**CITY OF ALBUQUERQUE
ADMINISTRATIVE APPROVAL (AA)- SITE DEV PLAN AMENDMENT
ROUTING & REVIEW SHEET**

APPLICATION #: 10022	PROJECT #: 1009168
PROJECT NAME: Richfield Park	
APPLICANT or AGENT: Kathleen Loudermilk	
PHONE # and E-MAIL: 573-5583	
ZONE ATLAS PAGE: C-17	
ADMINISTRATIVE APPROVAL (AA) for:	<input type="checkbox"/> EPC CASE <input checked="" type="checkbox"/> DRB CASE

DESCRIPTION OF REQUEST: ADD DECORATIVE WALL & WASH PAD

VERMEER SALES SW WASHINGTON ST NE	DRAWN BY DY DATE 2/23/12
	GRADING AND DRAINAGE PLAN	2012006-GRB
	TERRA WEST, LLC 5571 MIDWAY PARK PLACE NE ALBUQUERQUE, NM 87109 (505) 858-3100 www.tierrowestllc.com	SHEET # C1 JOB # 2012006

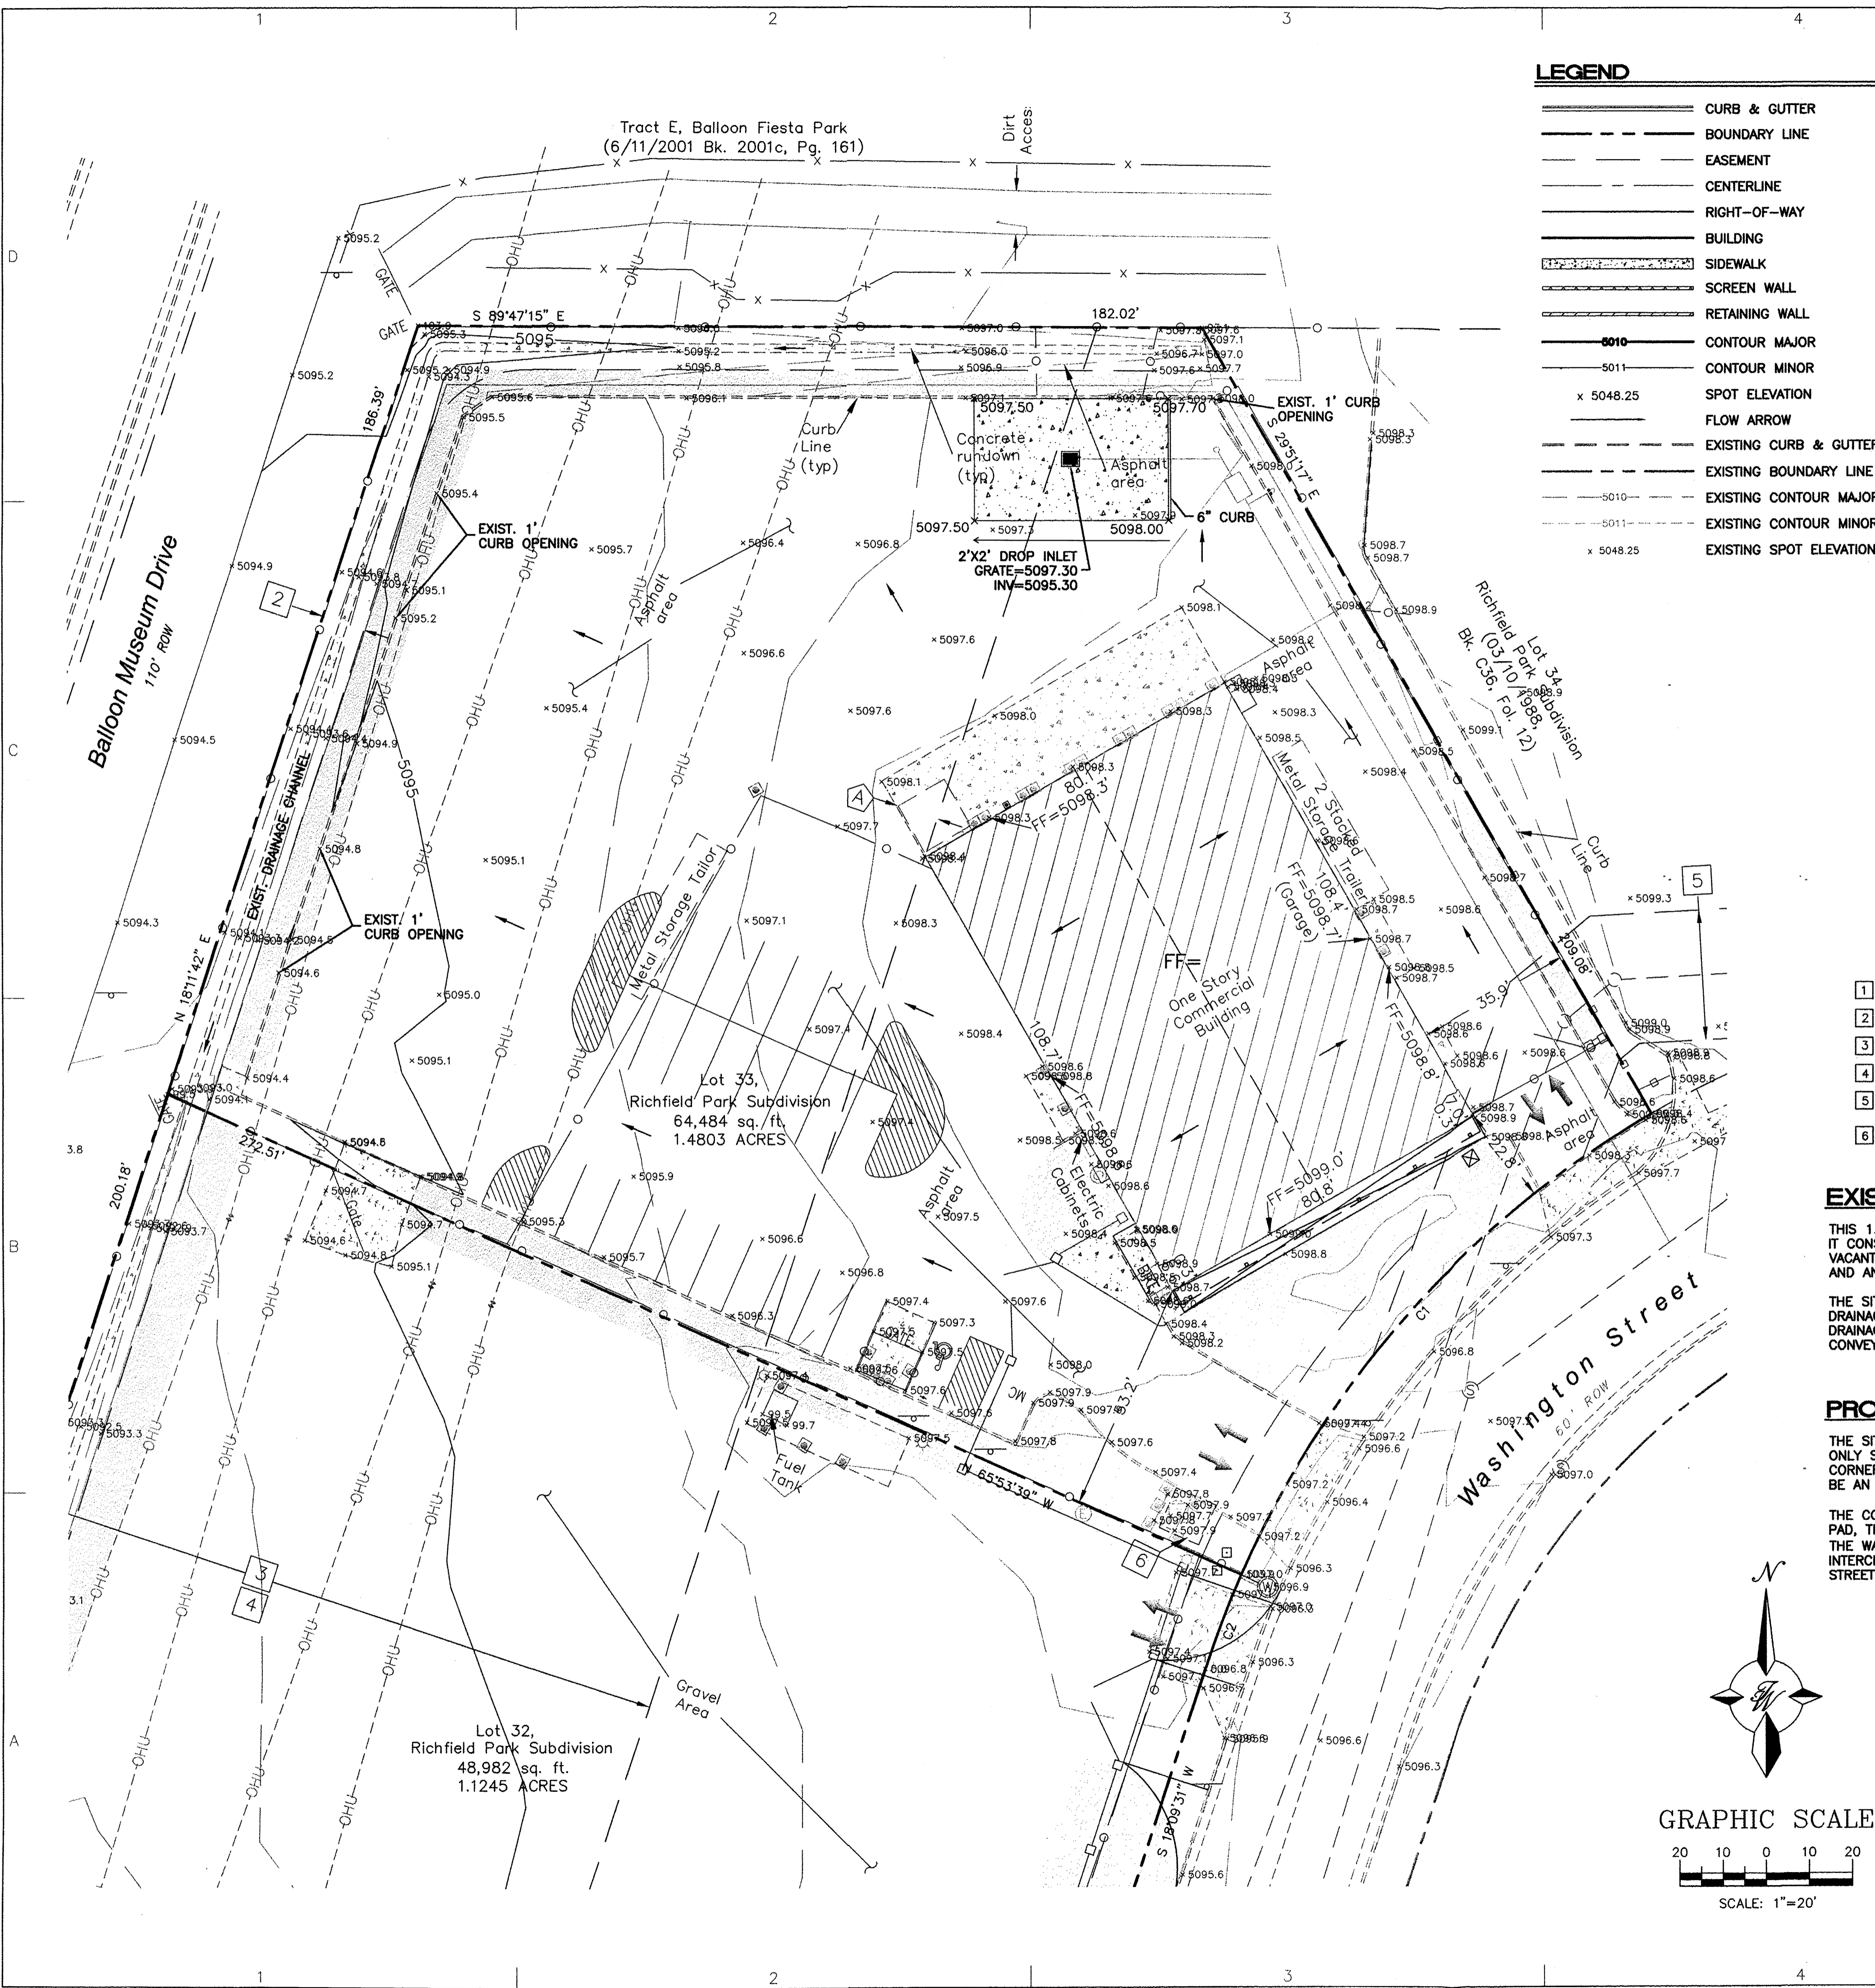
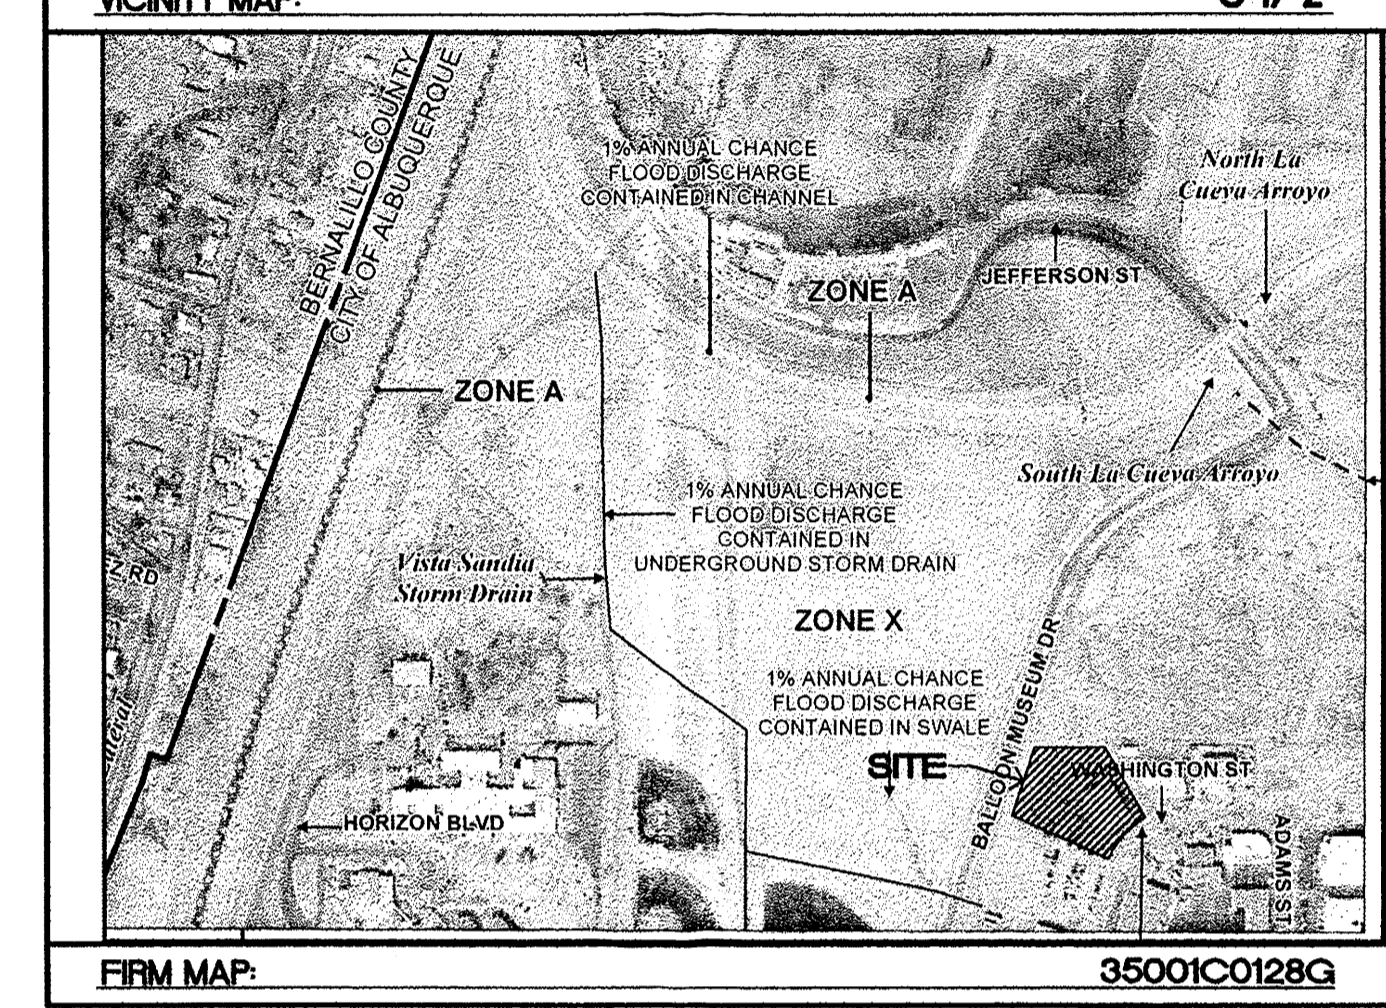
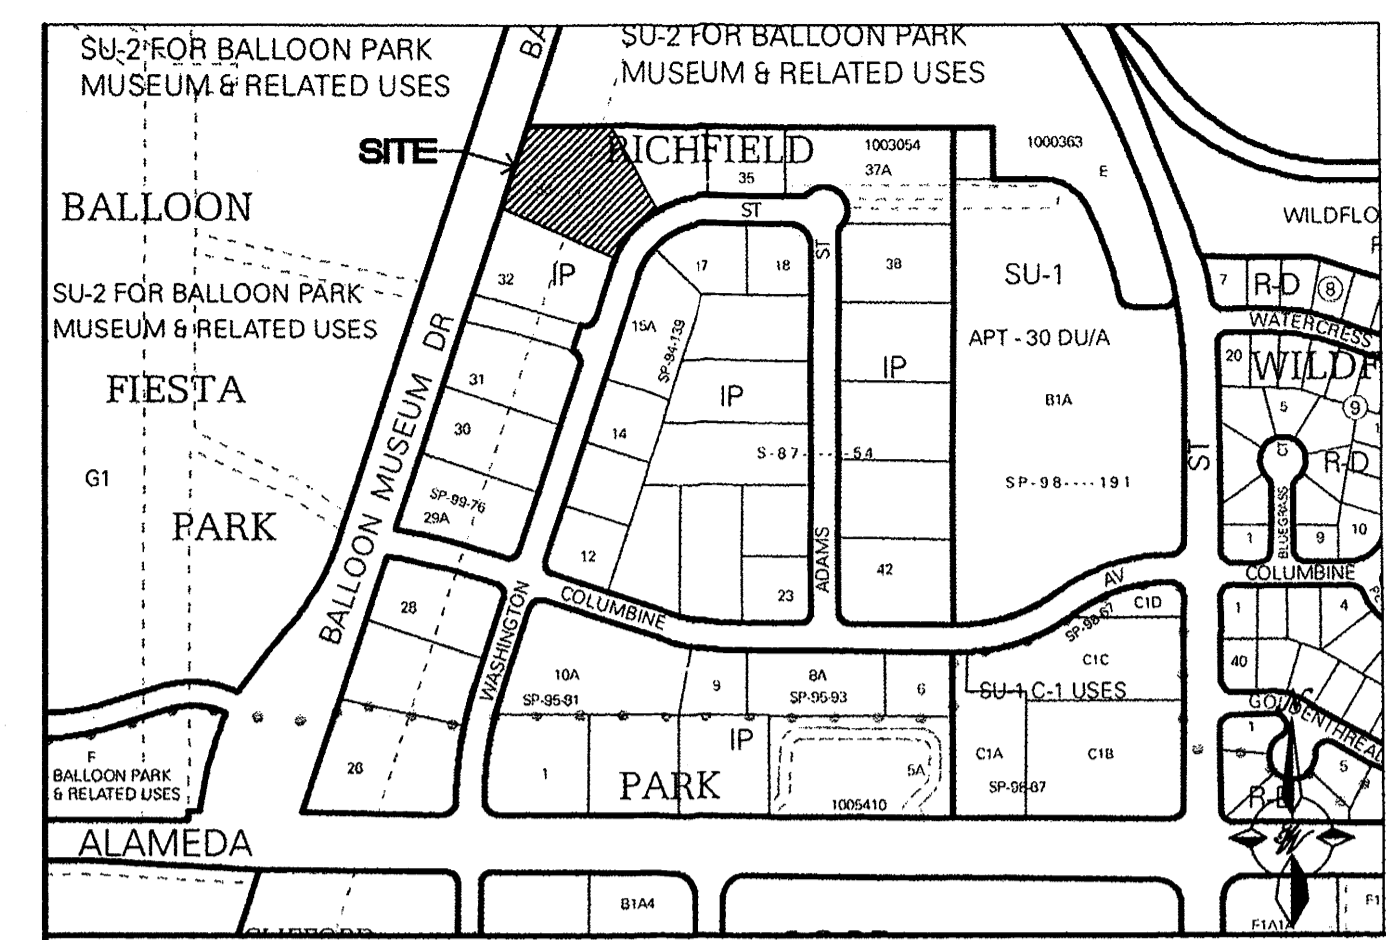
HYDROLOGY (505) 924-3986	DATE RECEIVED:
PLANS DISAPPROVED: Chris C. White	DATE: 6-11-11
PLANS APPROVED: Chris C. White	DATE: 6-20-12
COMMENTS: Hydrology agrees with Utiliter that upland stormwater flows should be diverted around this washing pad.	
Revised 6-28-12 (?)
